CITY OF PORTLAND

January 25, 1995

RE: 6 Portland Fish Pier

Your application to construct a 22' X 22' addition to be used as a maintenance shed, has been reviewed and a permit is herewith issued subject to the following requirements: This permit does not preclude the applicant from meeting applicable State and Federal laws.

SECTION A
NTS

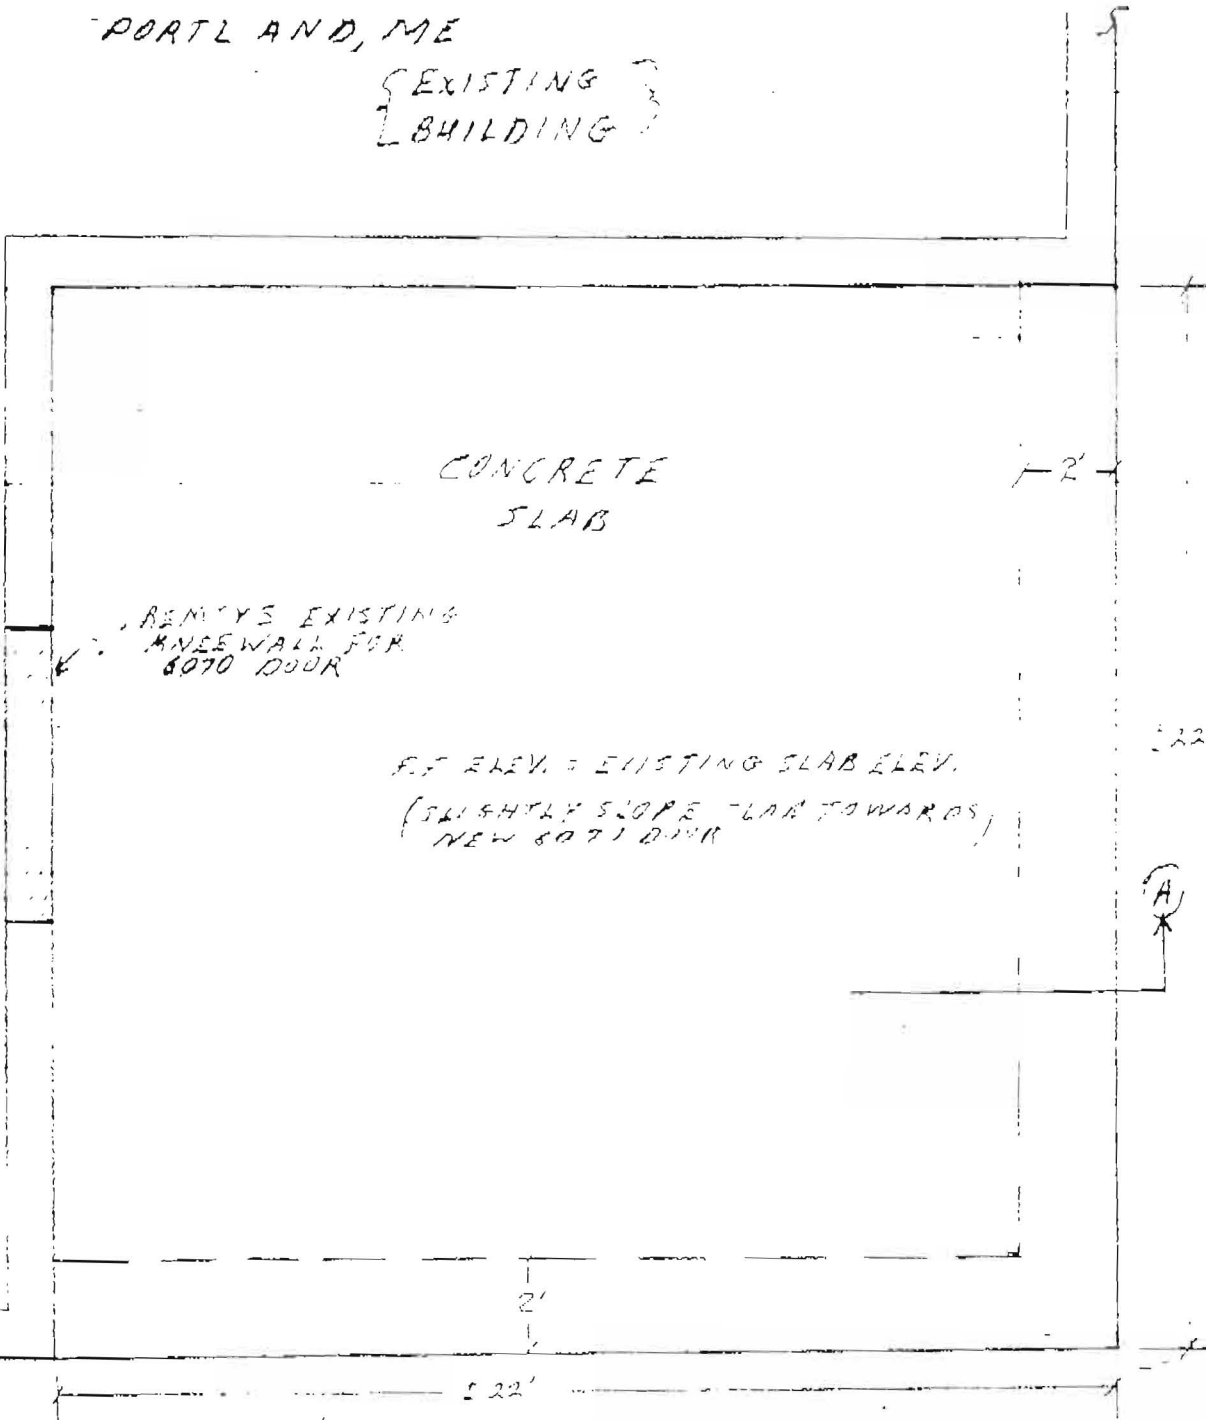
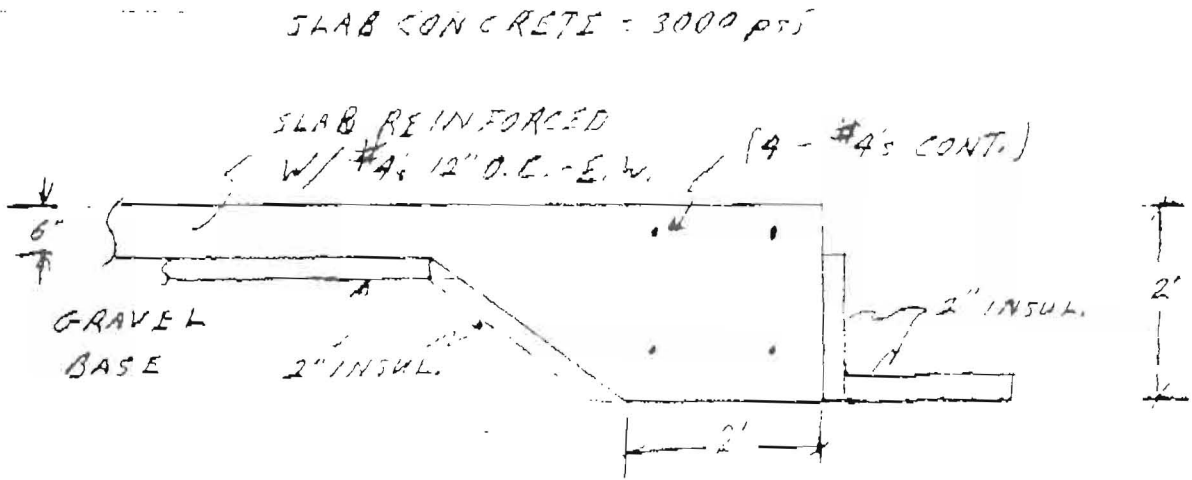
1. A portable fire extinguisher shall be provided as per NFPA #10.
2. A fire alarm system shall be extended to new construction.
3. Your proposed plan shows rafter, 2-2 X 12 at 24 o.c. spanning 22'. This proposed use of 2 X 12' is very close to the maximum load requirement. Also if drifting occurs the rafters could fail, therefore I'm requiring a structural engineers seal on the rafters design.
4. In my letter to you dated January 17, 1995, I stated that the final building plans include elevations. I feel that after reviewing your plans that there was a misunderstanding on the type of elevation I was looking for. I will be looking for a sill elevation meaning the height of the sill above the flood plain level. Please submit this information before work begins.
